PROJECT NO. 1002383	APPLICATION NO. 02DRB 01881
PROJECT NAME C.A.P. Properties	
APPLICANT / AGENT Tuvia West	PHONE NO. 858 3100 ext. 23
ZONE ATLAS PAGE 7-14	DATE SUBMITTED 12/12/02

ONE STOP CASE TRACKING LOG

**RE: Preliminary/Final Plat Approval
Tracts 1 & 2, C.A.P. Properties
Zone Atlas Page F-14**

Plat of  
Tracts 1 and 2  
**C.A.P. Properties**  
Albuquerque, Bernalillo County, New Mexico  
November 2002

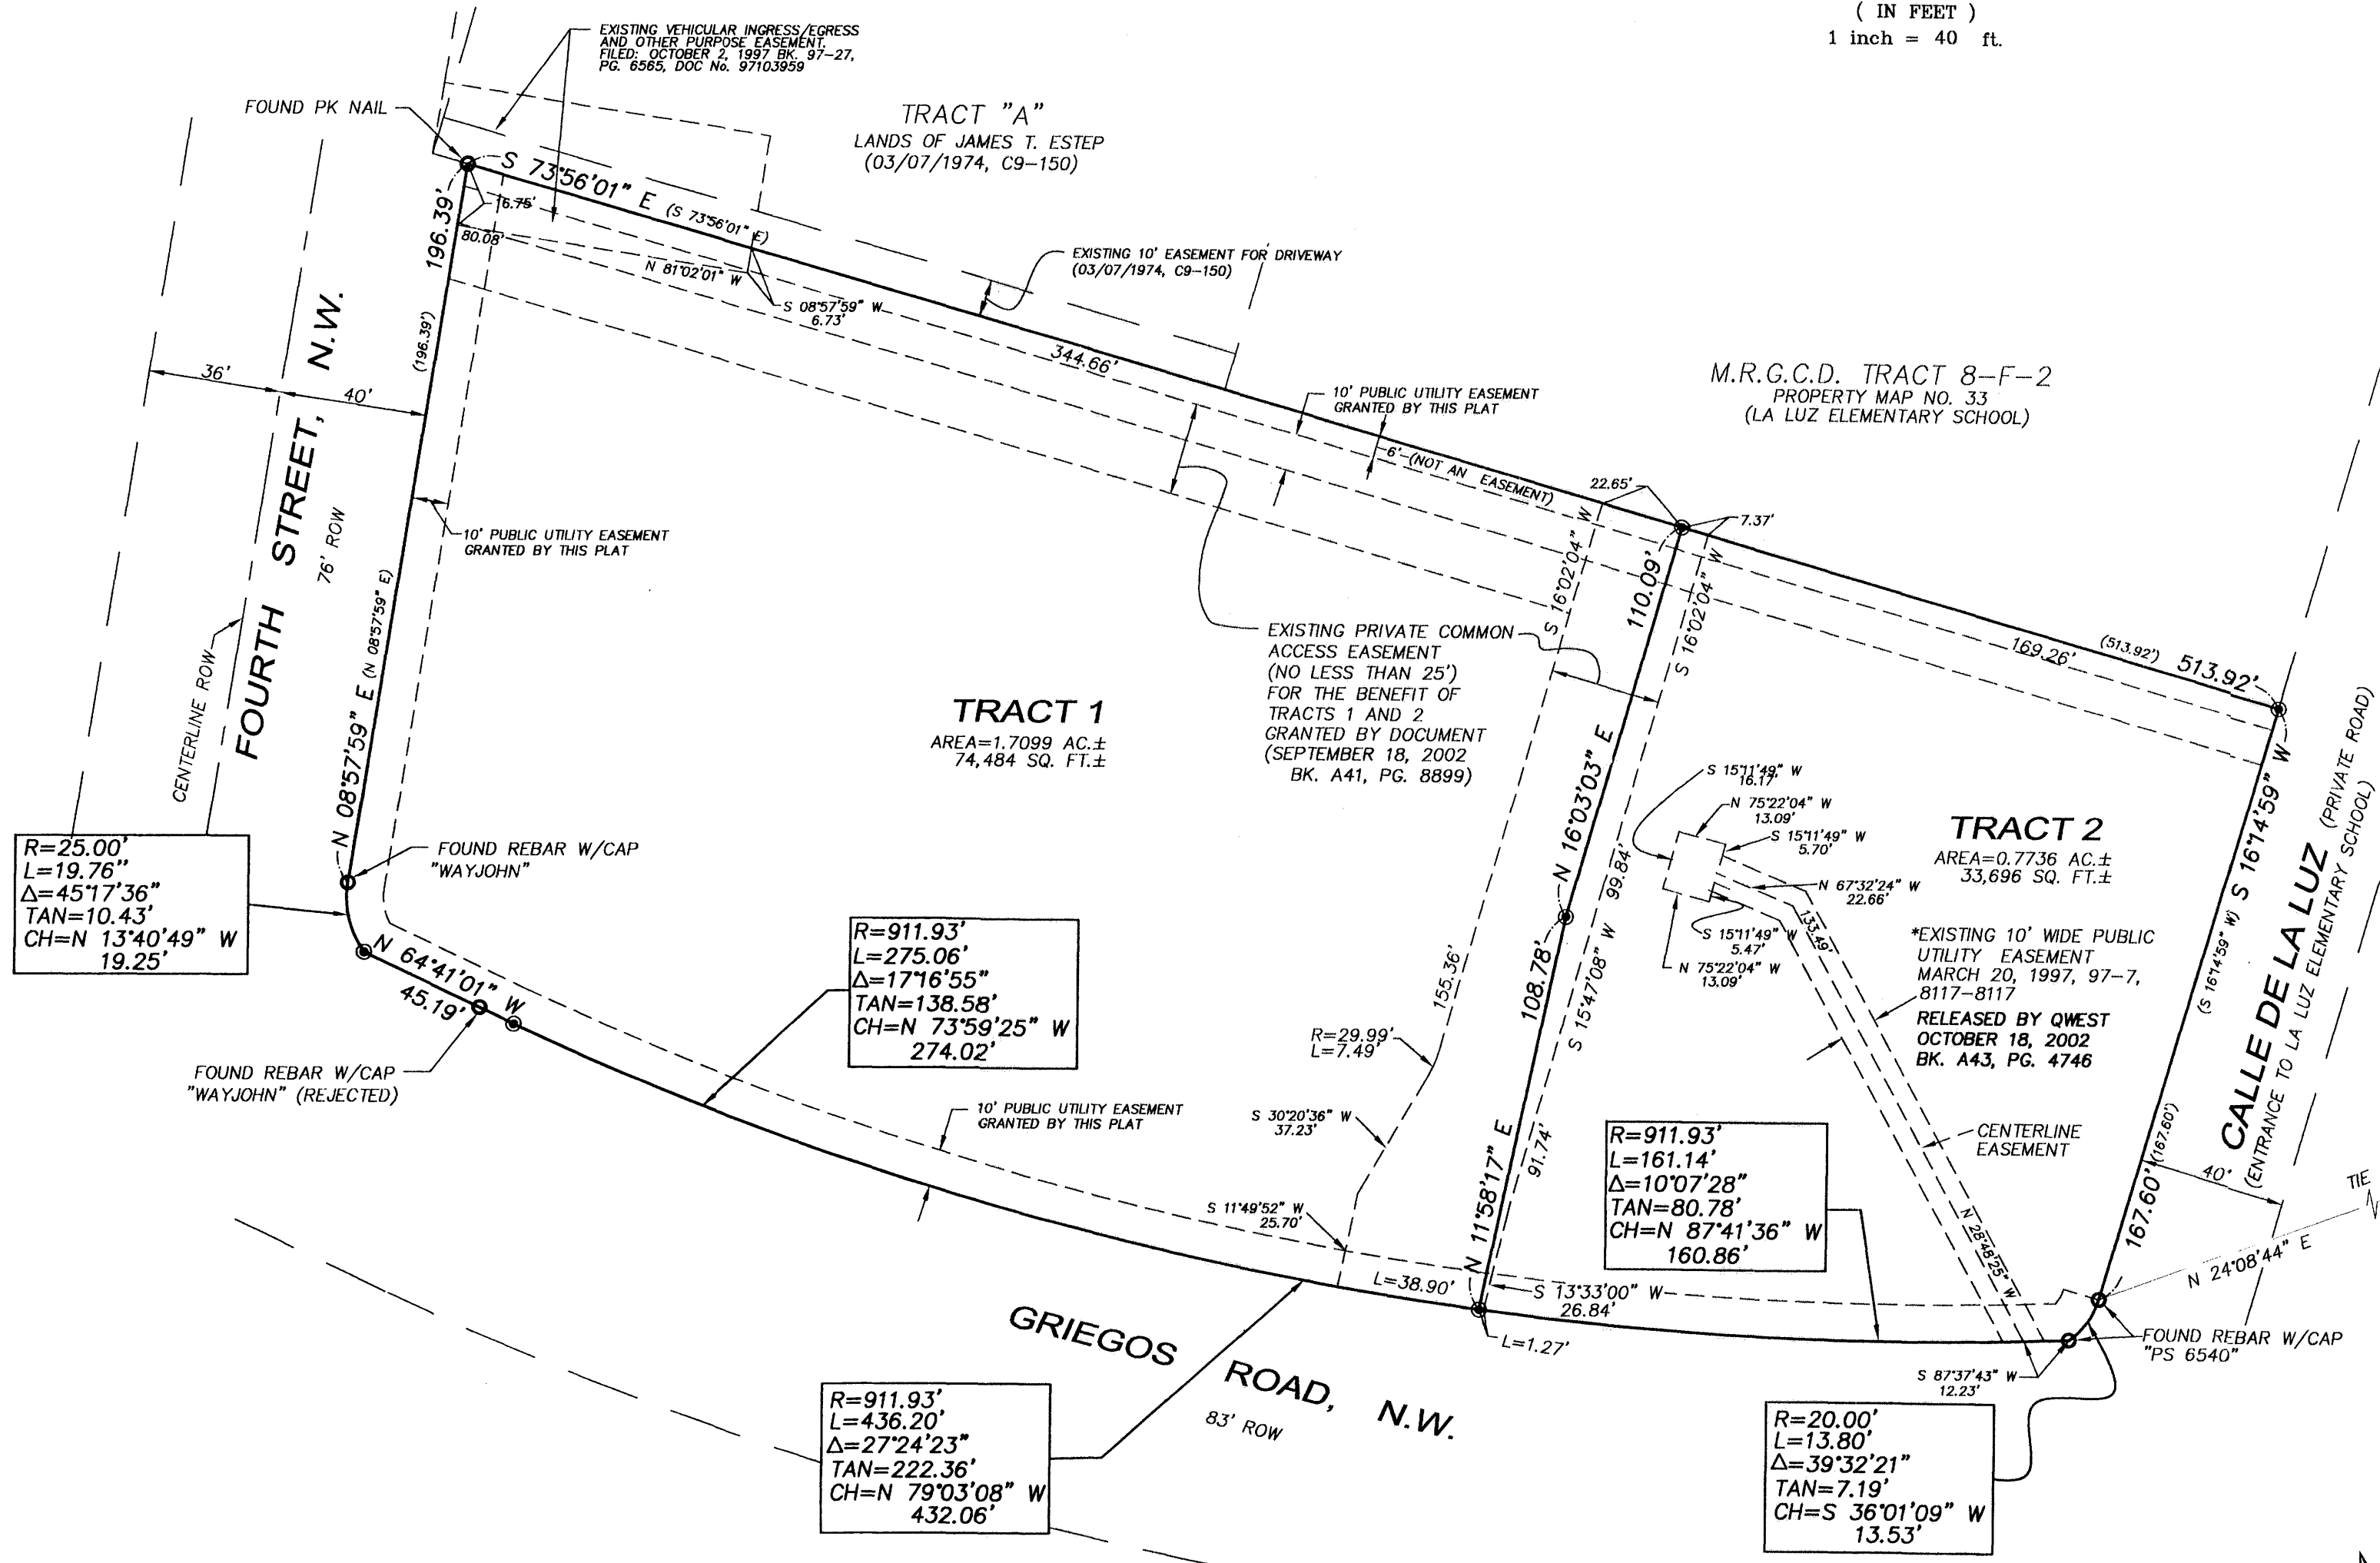
TRANSPORTATION DEV (505) 924-3990		
PLANS DISAPPROVED TR	DATE 12-12-02	DATE
PLANS APPROVED TR	DATE 3-17-03	DATE
1 - Dedicate R/W 10' from face of streets curb on GRIEGOS.		
COMMENTS:

UTILITY DEV (505) 924-3989		
PLANS DISAPPROVED RL	DATE 12/13/02	DATE
PLANS APPROVED RL	DATE 3/12/03	DATE
Need separate water/sewer accounts established. Show location of existing and proposed meters		
COMMENTS:

* Note: disclosure appears to be incorrect; the
coord ~~are~~ appear to be local ground.
Also, the tie seems to locate the plat
about 10'± to far east.
